From: Amanda Scholes on behalf of Planning.Responses
Sent: 30 January 2020 08:44
To: Planning Scanning
Subject: FW: 4 Lake Lane -ground infiltration rate. BN/59/19/DOC

|        |                                       |                                | August 2019 | 1:200    | 1217 P 001     |

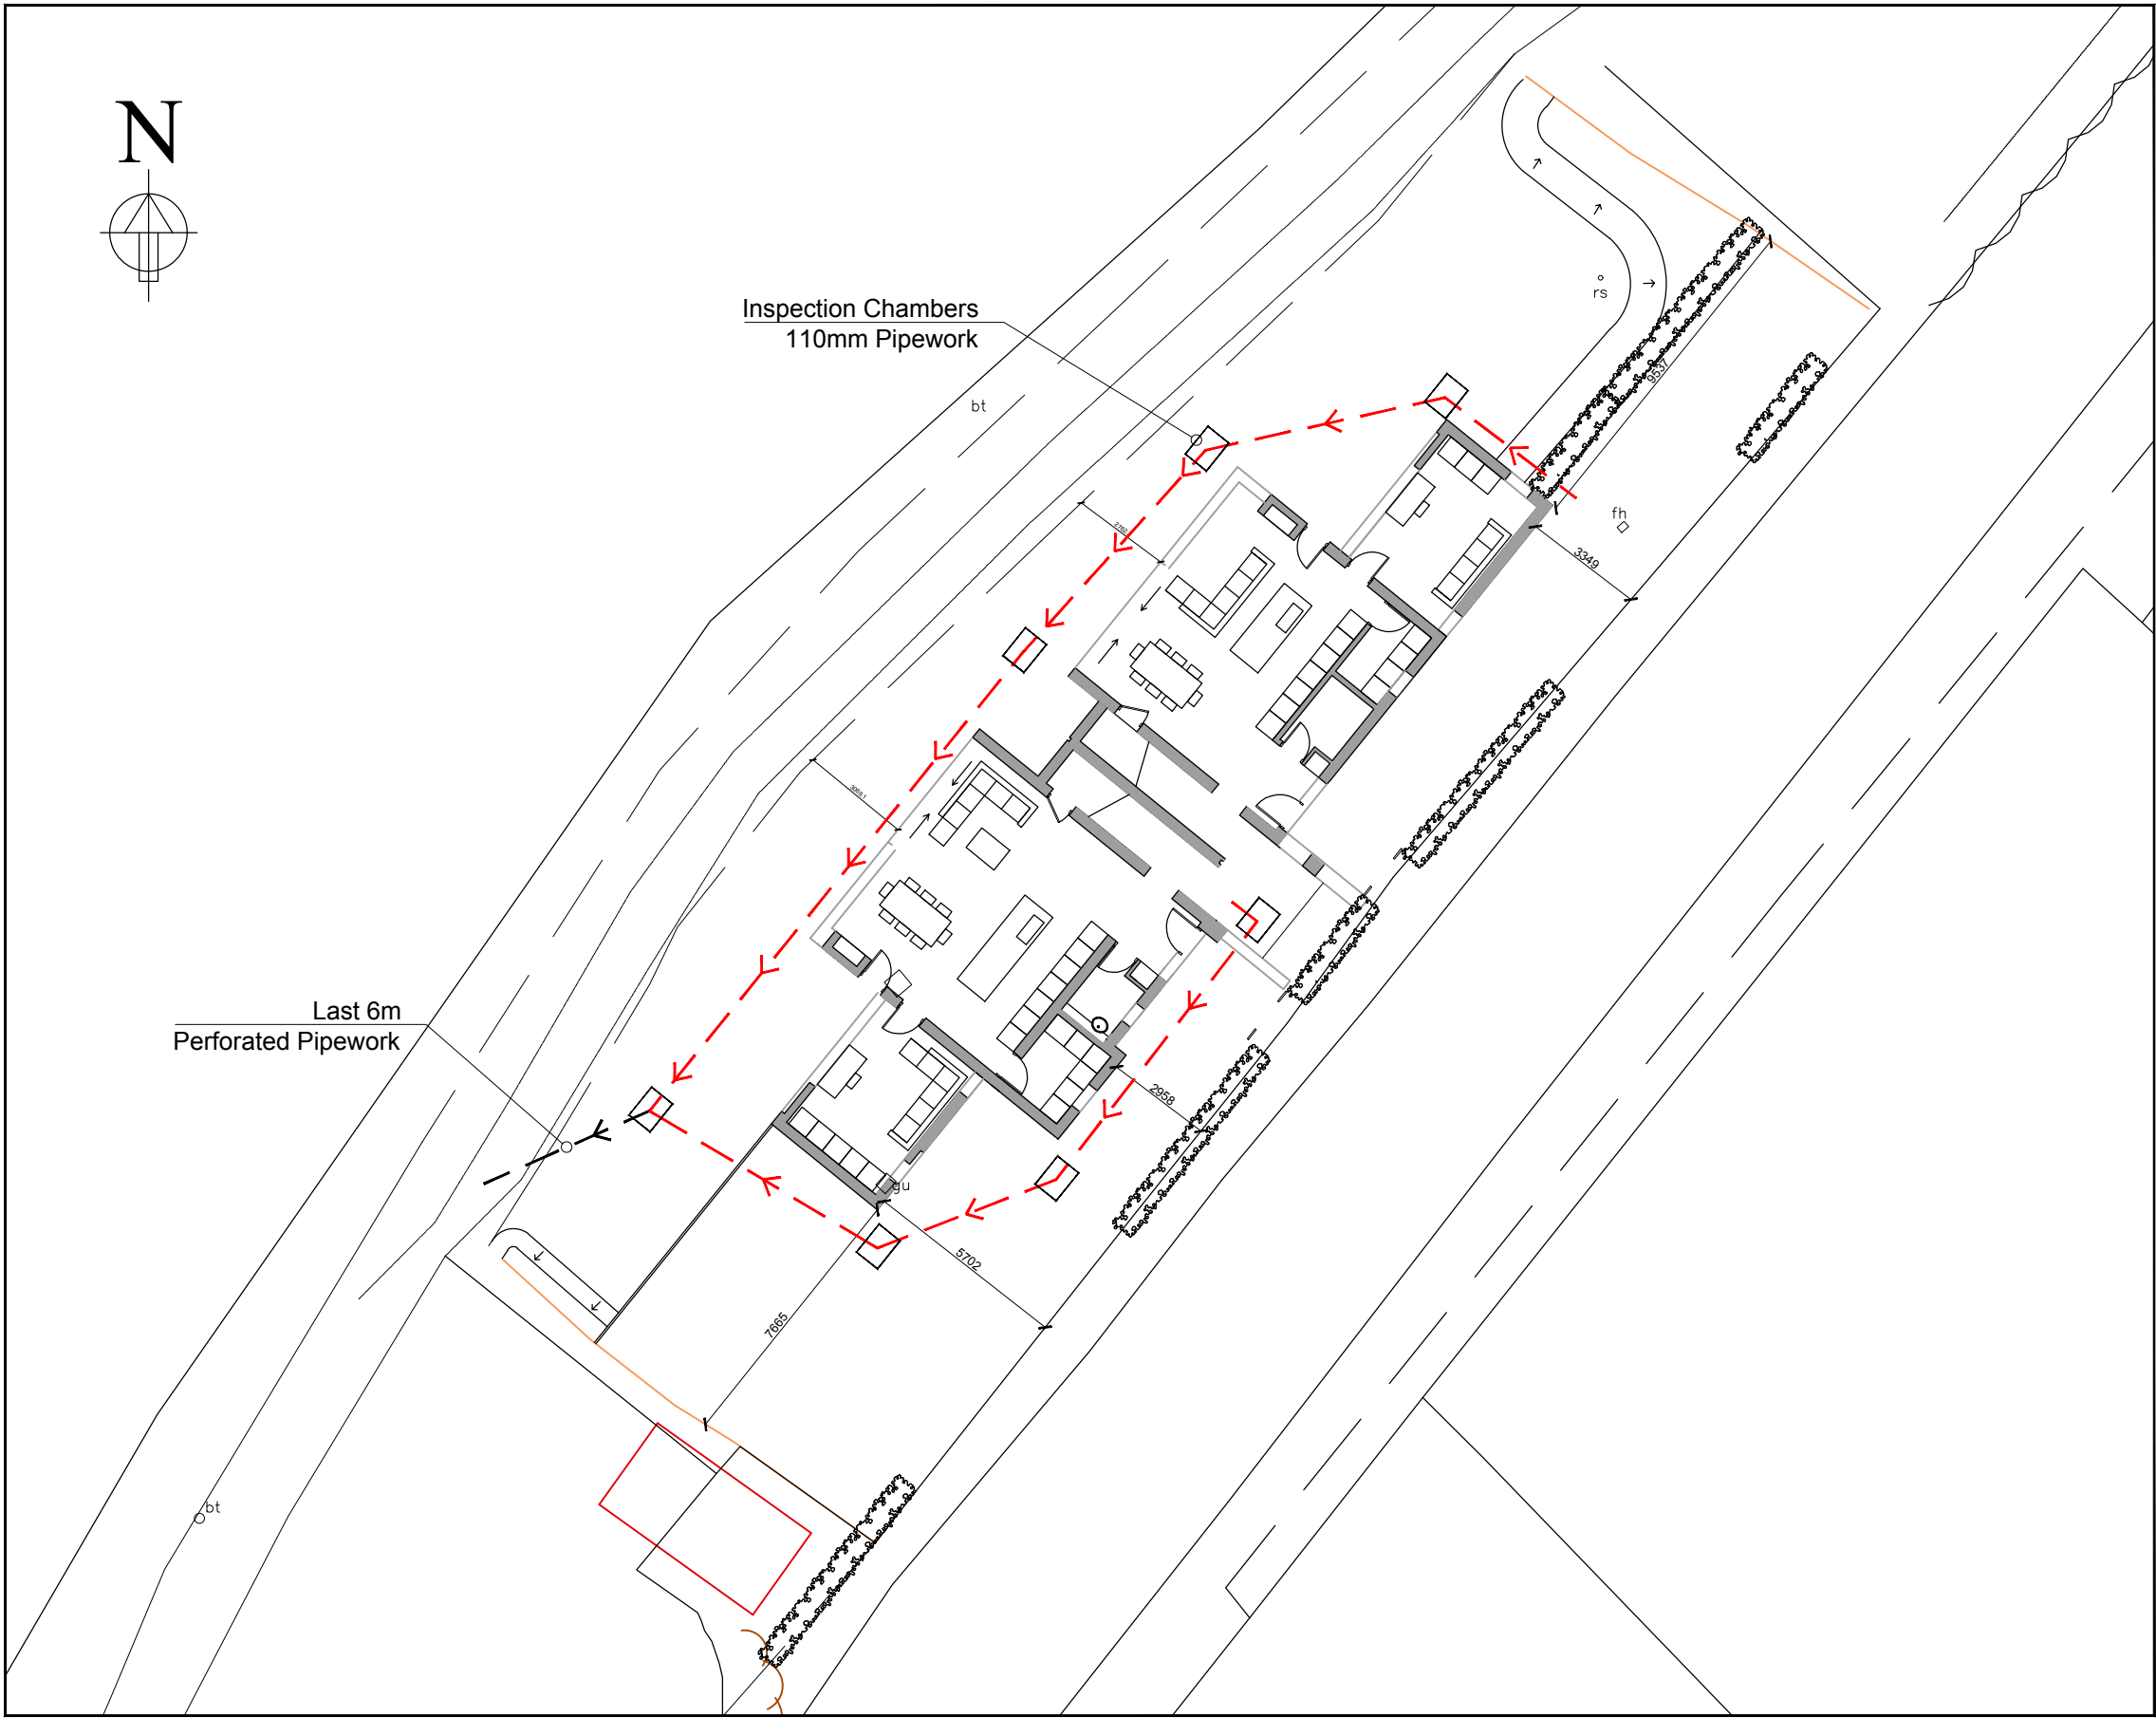
> I can confirm Paul Cann has seen both plans submitted with the application (attached). He has commented "the drawings are still lacking sufficient detail".

>> In terms of a way forward, I suggest the applicant amends their plan to show fully detailed arrangements. This should include manhole cover levels, invert levels, all pipe diameters and gradients. Construction drawings are also required for manholes, pipe bedding, bedding/spec for perforated pipe section, gravel finished area around the building frontage, etc.

>> "Engineers Further Comments Regarding Condition 5 Our checklist has been submitted. Within the checklist it is indicated that no groundwater monitoring or infiltration testing has been completed and that justification has been provided for not using infiltration. Please can this justification be provided.

As I said previously he obviously has not seen my As - Built drawing with all the requested information shown apart from the gravel Specs which were Terran geotextile wrapped in the french drain and 100 mm thick laid on a geotextile sheet along the front of the two houses. I think I sent you this drawing Regards, Tony

> Did the person who asked for further information receive my drawing ,because most of the information requested is on my As / Built drawing apart from the surfacing gravel spec and that used in the 12.0m run of French Drains.

>> Following my visit to this site I have prepared an As - Built drawing indicating the extent of the new impervious ground cover and the foul and storm water disposal systems.

>> The impervious areas now comprise the 100 m2 roof scape and two areas of pcc paving slabs which drain from their edges onto lawned areas, or other areas surfaced with timber chipping or single size gravel.

>> You are no aware that the subsoil conditions to some depth are stiff clay having an extremely low infiltration rate that was felt at the time to be unsuitable for disposal by infiltration of the rain water discharged from the roof scape.

>> On the advice from a senior engineer working for the Arun DC the final 6.0 m runs of the two 100 mm dia. storm drains serving the roof scape were constructed using 100mm dia. perforated pipes surrounded and with the trenches filled using a single size gravel to form French Drains.

>> Finally the Discharge Pipe size was throttled from 2/ 100 mm dia. pipes to 1/ 75 mm dia pipe discharging into the Rife through a pcc paving slab buried in the bank behind the Wattle panel lining.
